Recommendation Report for Planning Permission

REF NO: F/10/18/PL

LOCATION: Waterbury House
Ford Road
Ford
BN18 0BH

PROPOSAL: Construction of 5 No. 1 bedroom flats together with staff accommodation, hard landscaping & parking, (resubmission following F/29/17/PL). This application affects the setting of a listed building & is a Departure from the Development Plan.

Proposed West Elevation

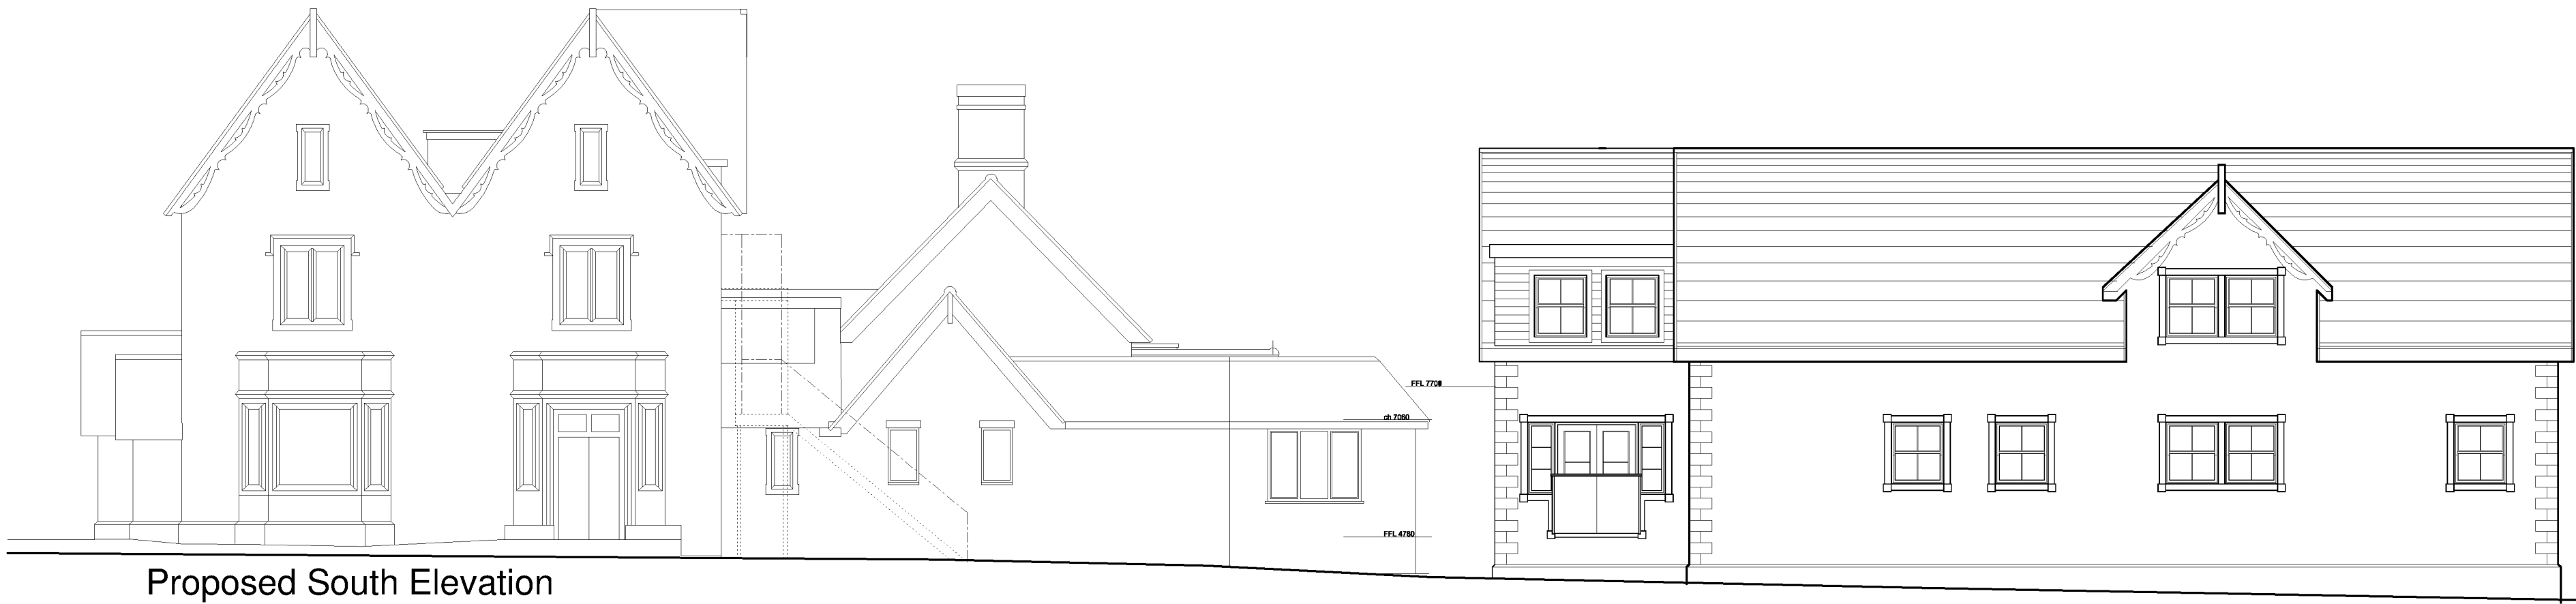
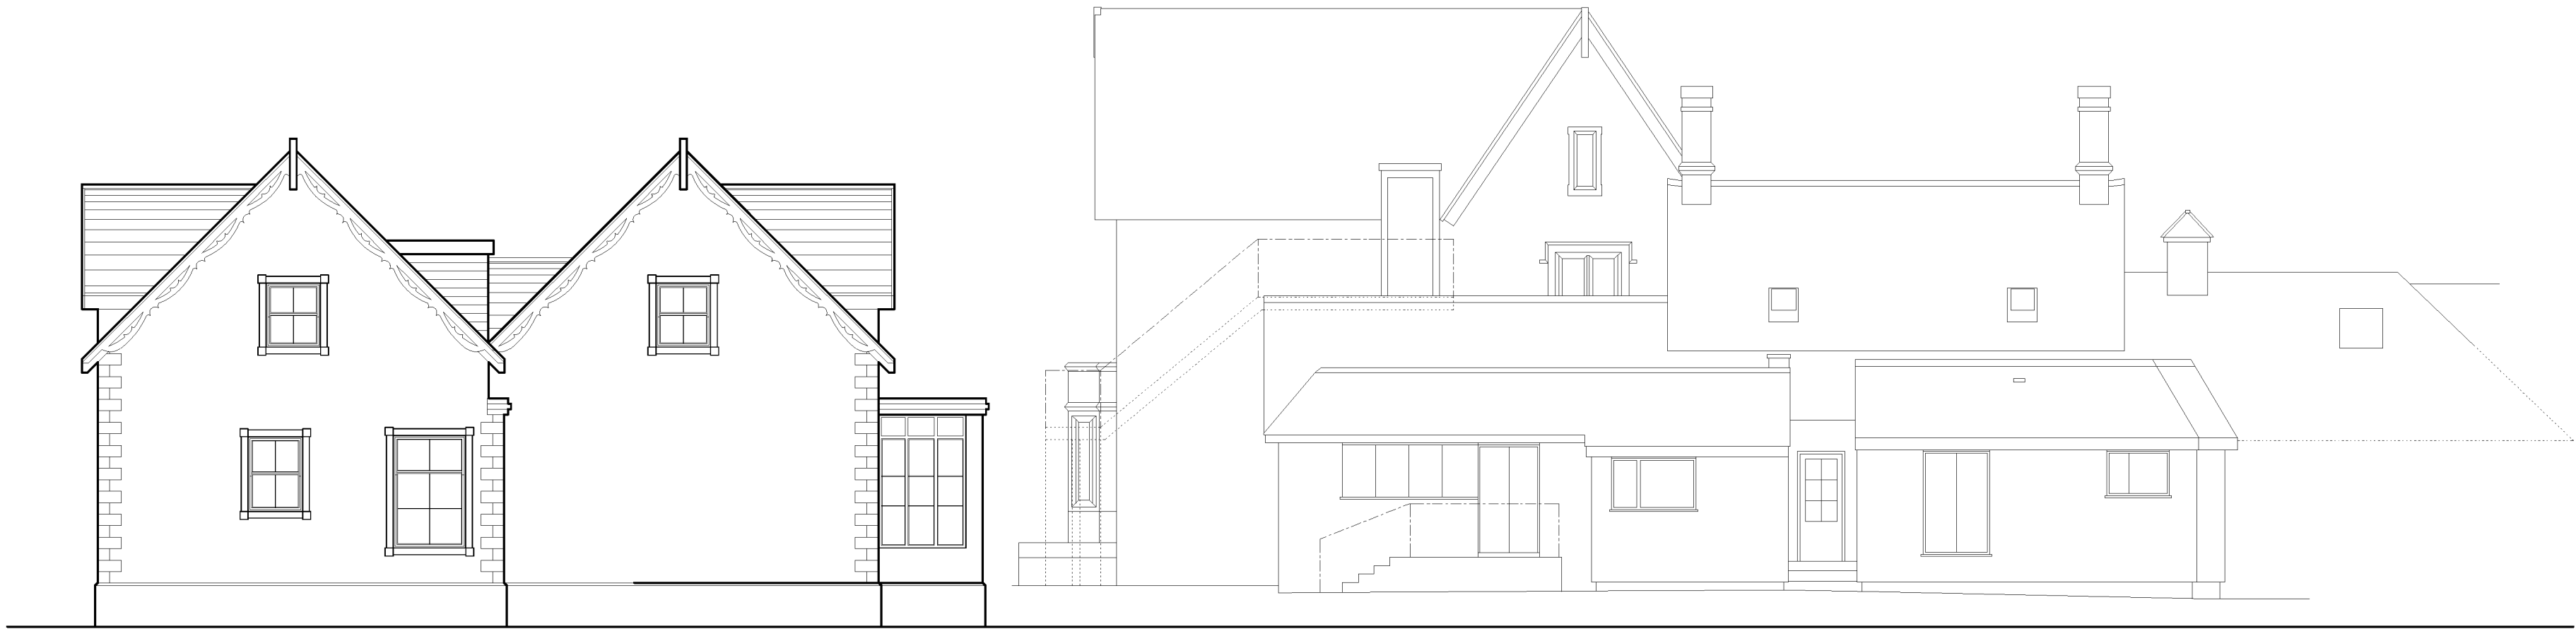
However, the unit would be located 3m from the southern boundary with the railway line and 11m from the tracks. This close proximity means that the occupiers of the units would be subjected to noise from trains using the railway line. The applicants have undertaken a noise assessment and the Council's environmental health officer has been consulted. She has objected to the proposal on the basis that with the exception of 'night-time with windows closed' noise levels will not achieve the levels set in BS8233. Further, even with an acoustic fence, the external levels will only just achieve the 'serious annoyance' level. On this basis material harm would result to the residential amenities of the occupiers of the units and the proposal cannot be supported.

considered unlikely that noise to the bathroom would adversely affect residential amenity and the units lounge area would be unlikely to be used for sleeping at night. No other windows served this area so alternative means of ventilation were difficult to achieve. With this current application bedroom windows are located at ground floor facing onto the railway line and first floor in the side elevation. The number of units has also increased.

The most recent approval F/4/13 granted permission for a 4 bedroom unit which had one bedroom window at ground floor facing the railway line and a defined patio area which has been removed from the proposal. The use has therefore intensified and the internal floor layout is more likely to result in noise nuisance to residents. There are now 3 flats at ground floor with their bedroom windows facing the railway line.

- 1 Having regard to the design of the building and the close proximity of proposed bedroom windows to the railway line the proposal would give rise to an unneighbourly form of development by way of excessive noise levels which would be prejudicial to the residential amenities of the occupiers of the development in conflict with policies DDM1, and QE DM1 of the Arun Local Plan.
